Ribble Valley Borough Council
Housing & Development Control

Your ref: 3/2023/0546
Our ref: D3.2023.0546
Date: 15th September 2023

Application no: **3/2023/0546**

Proposal: **Demolition of existing single-storey side and rear extensions, and construction of two-storey extension to the side and single-storey extension to the rear.**

Rev. B - Height of extension roof further reduced and white render finish indicated
planner request - P.E. - 08/09/2023

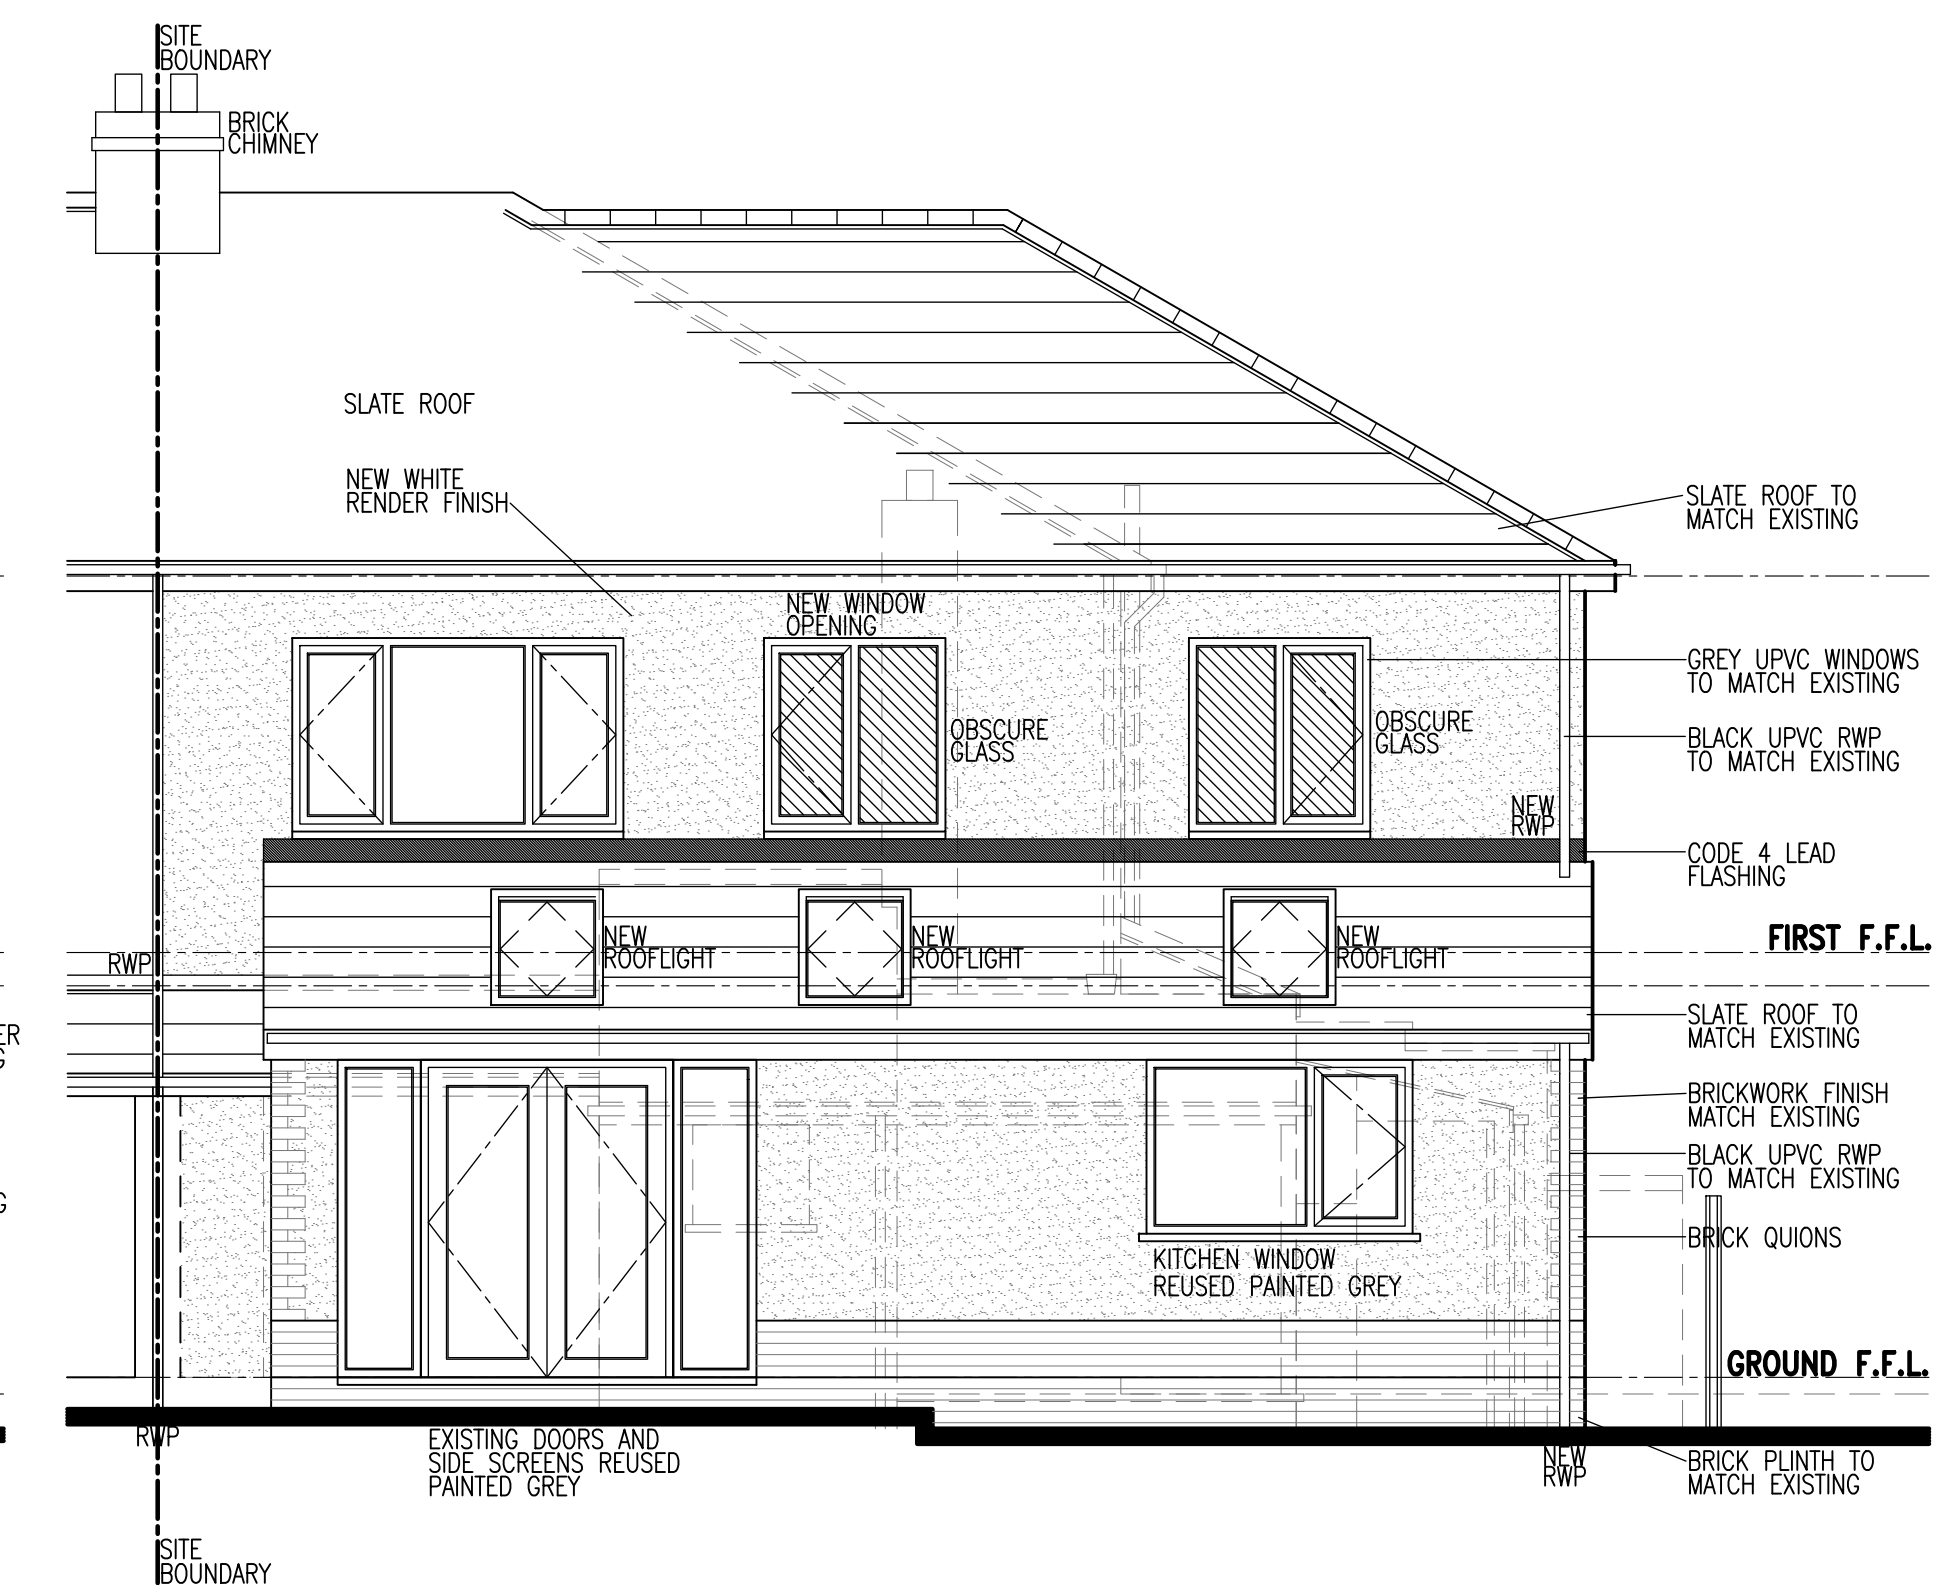
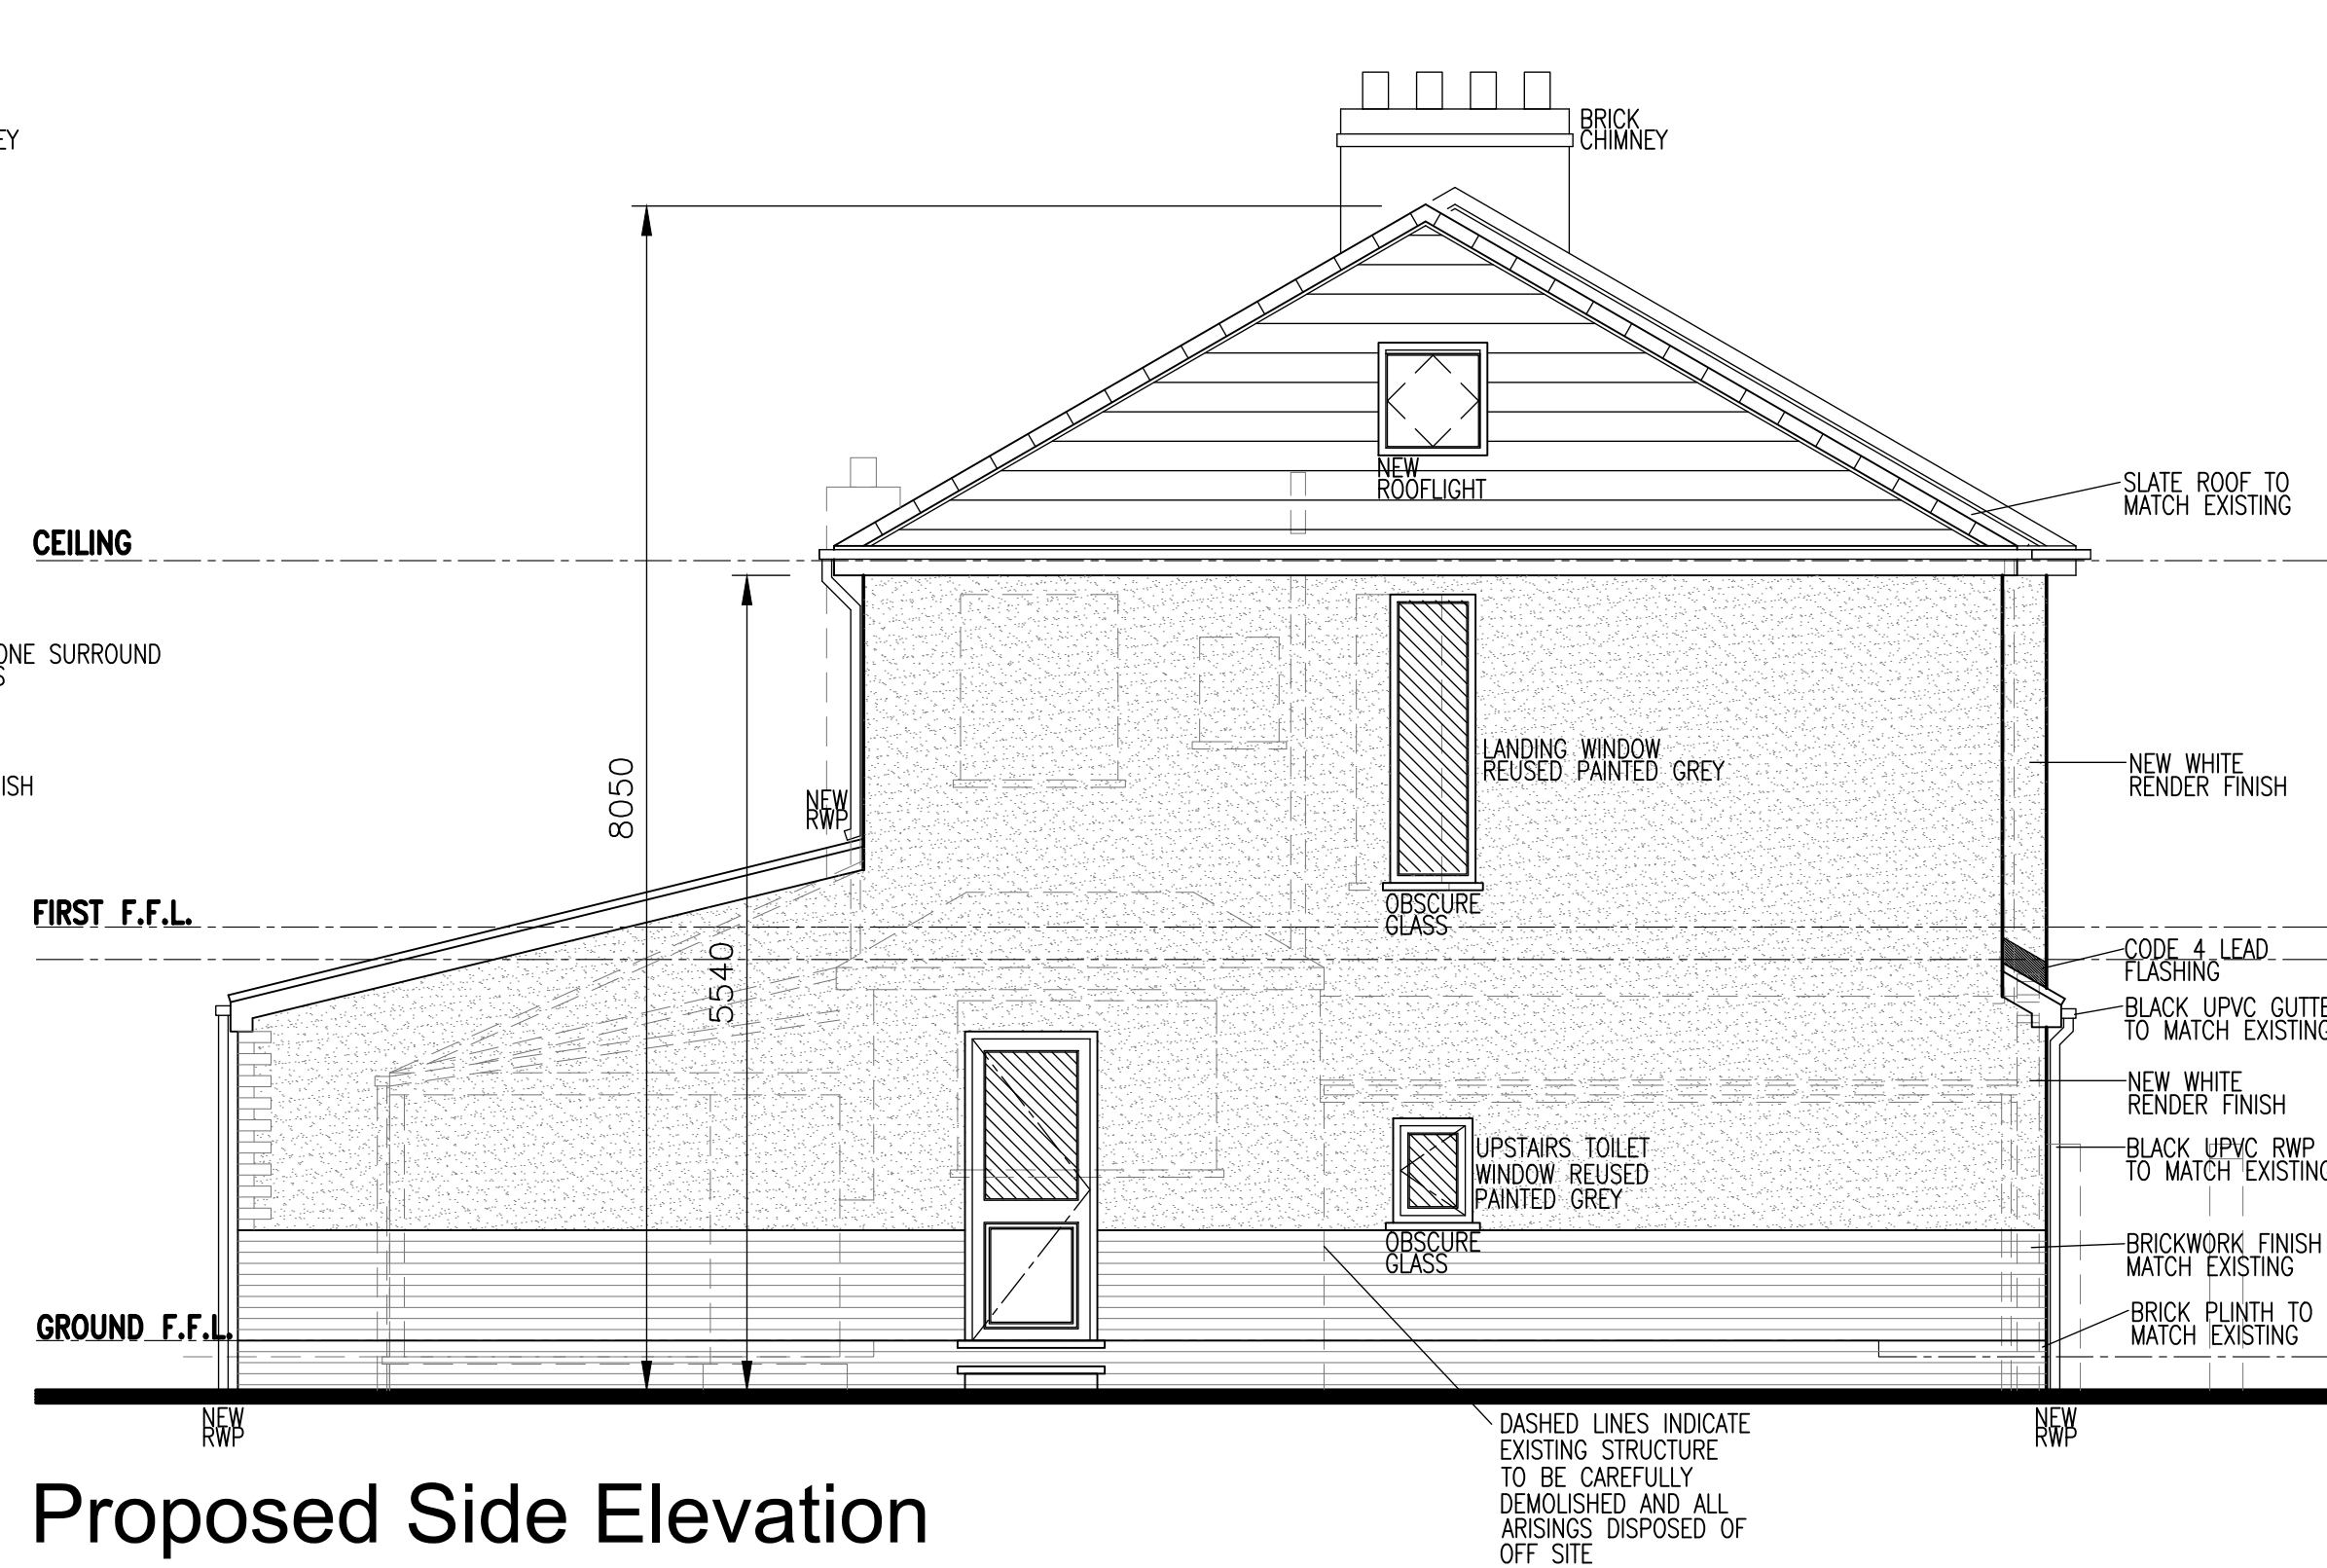
The LHA have reviewed drawing number Wilson/02 Rev A titled "Proposed Layouts" and are aware that the number of bedrooms at the dwelling will increase from 3 to 4. For the dwelling to comply with the LHAs parking guidance as defined in the Joint Lancashire Structure Plan, the LHA require the dwelling to provide 3 car parking spaces.
